From: Laura Gibbons
Sent: 13 September 2018 16:11
To: Planning.Responses
Subject: RE: Planning Consultation on BE/88/18/DOC

Engineers Comments Regarding Condition 3- surface water drainage scheme

APPLICATION NO: BE/88/18/DOC

Site Address: Beech Cottage 99A North Bersted Street Bersted

Detail: Foul and SW drainage

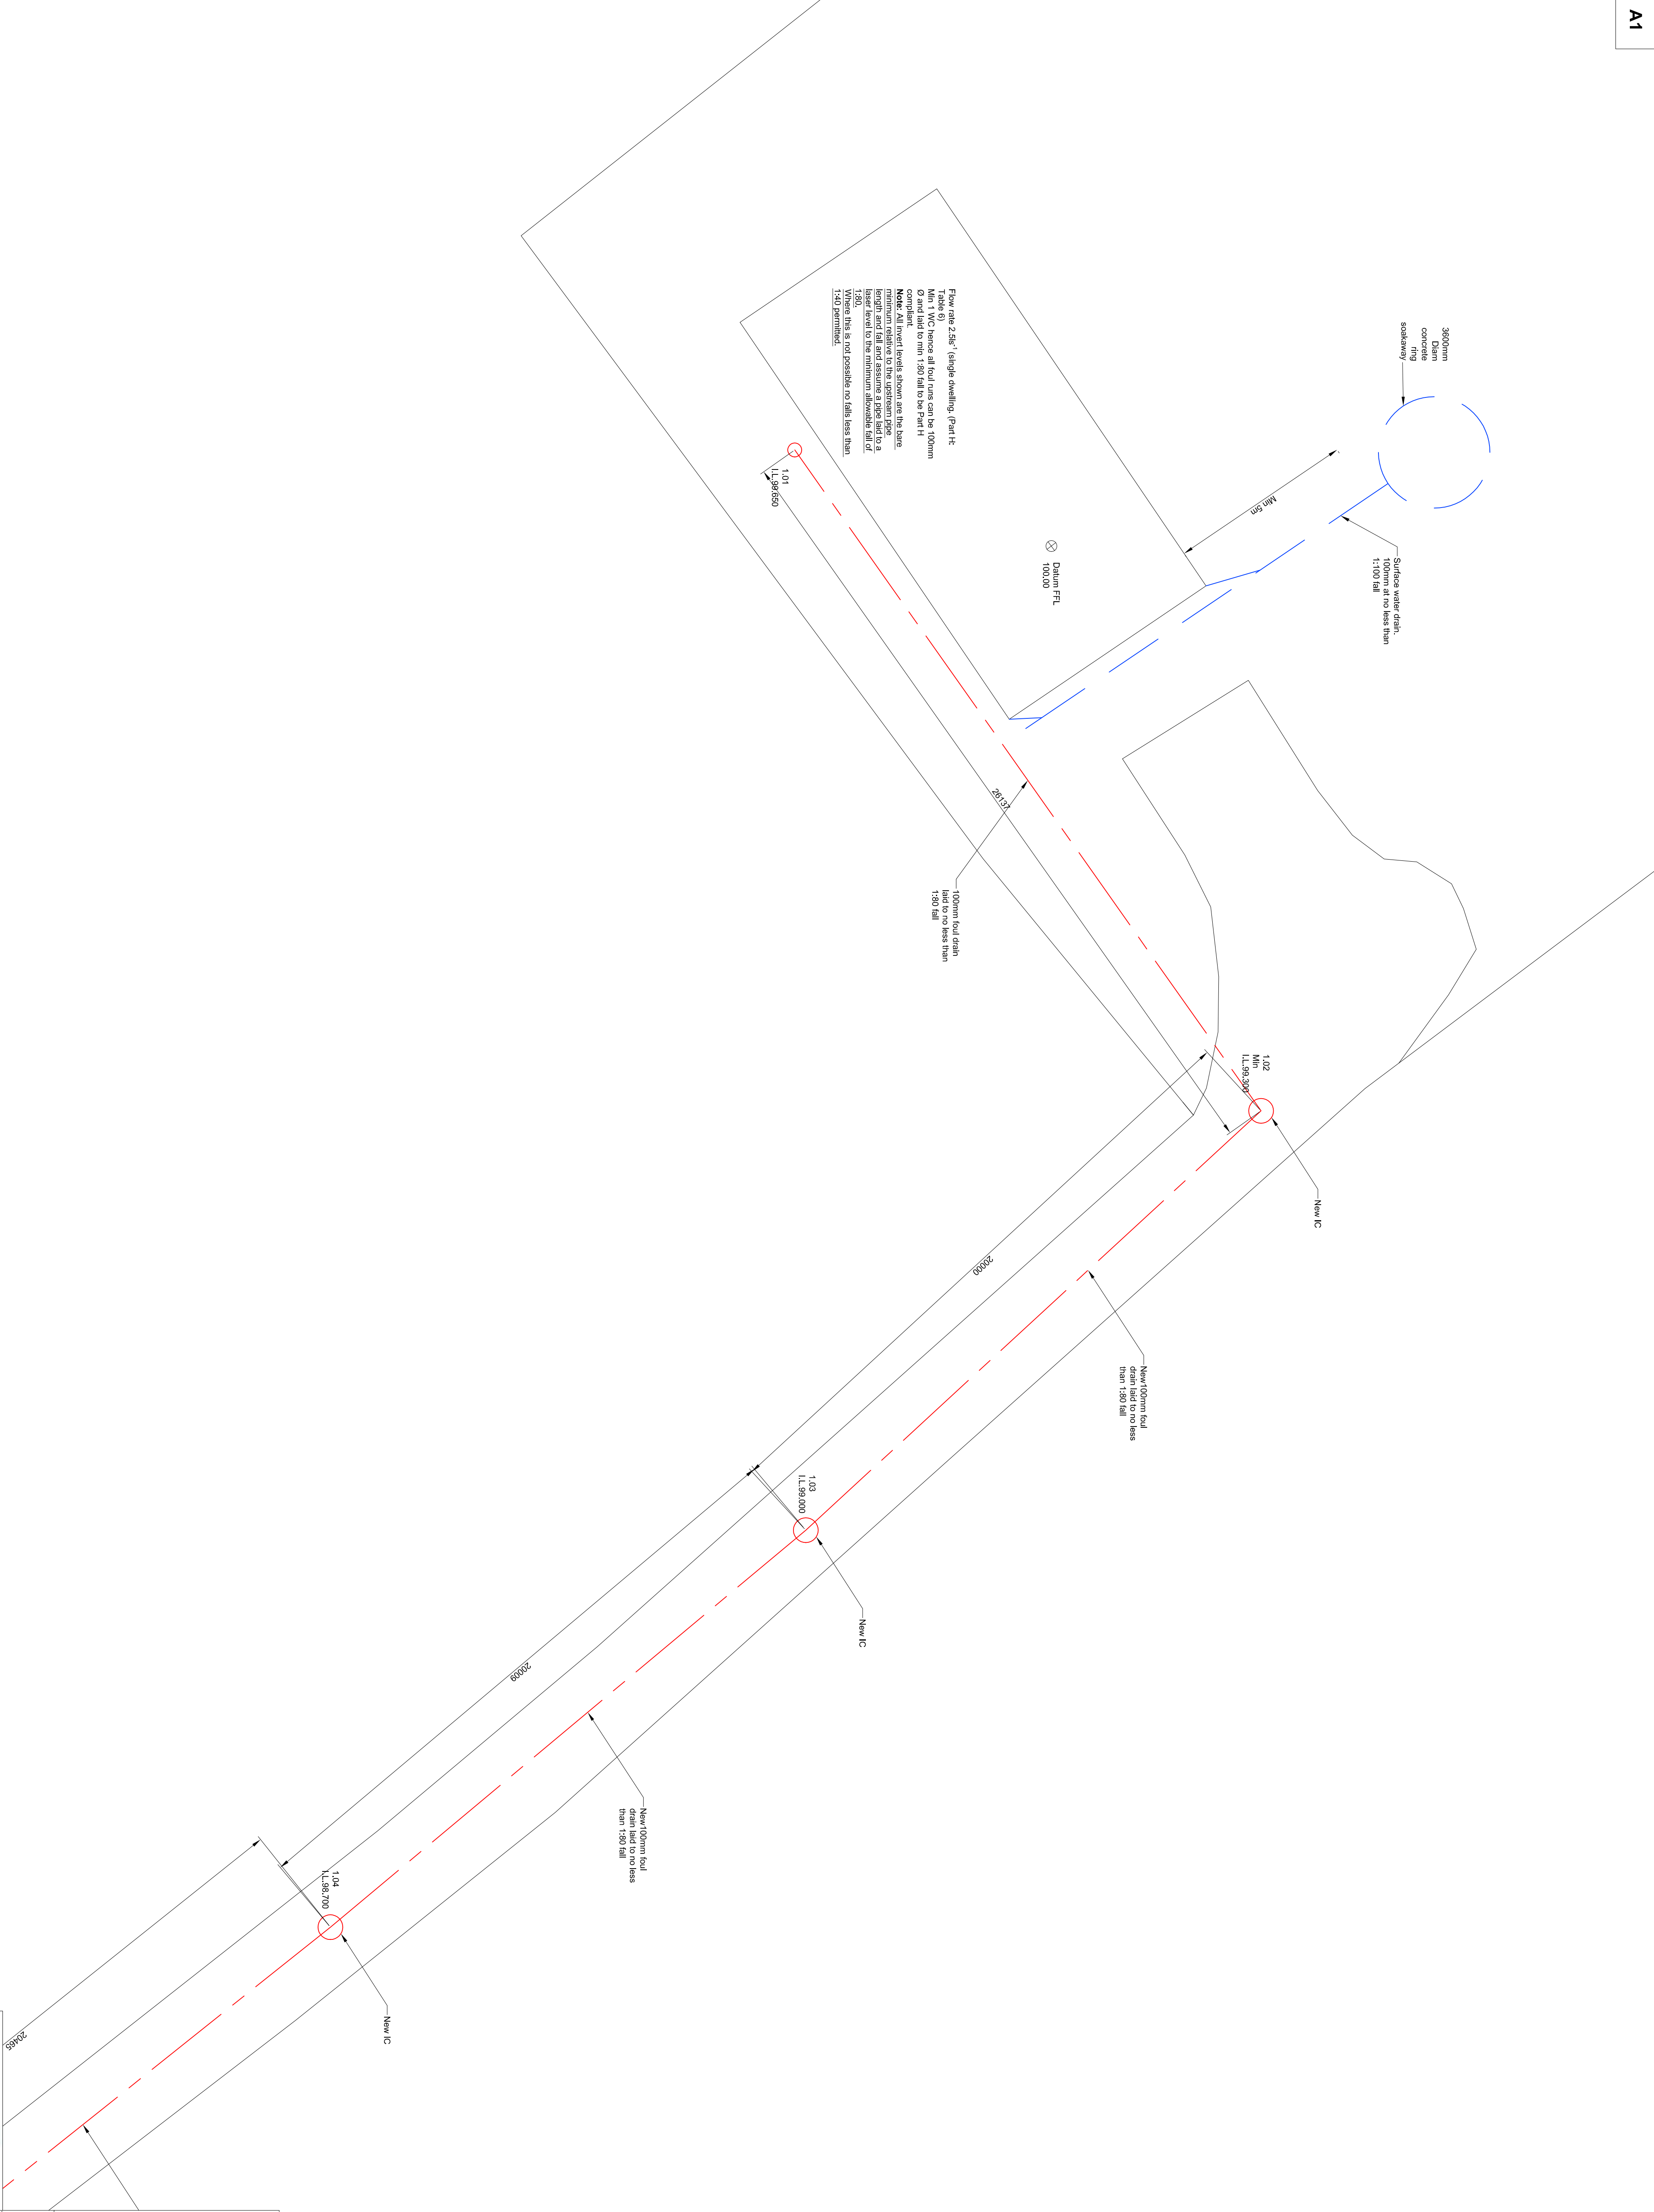
- Please provide further detail regarding the winter groundwater monitoring that was carried out.
- Please ensure a minimum factor of safety of 2 is used in design of soakaways.
- Please provide construction detail drawings of the proposed ring soakaways, and pipe protection details.
- Please amend the drainage layouts to include invert levels and cover levels of pipes and soakaways. Catchpits need to be provided upstream of all connections to soakaways.
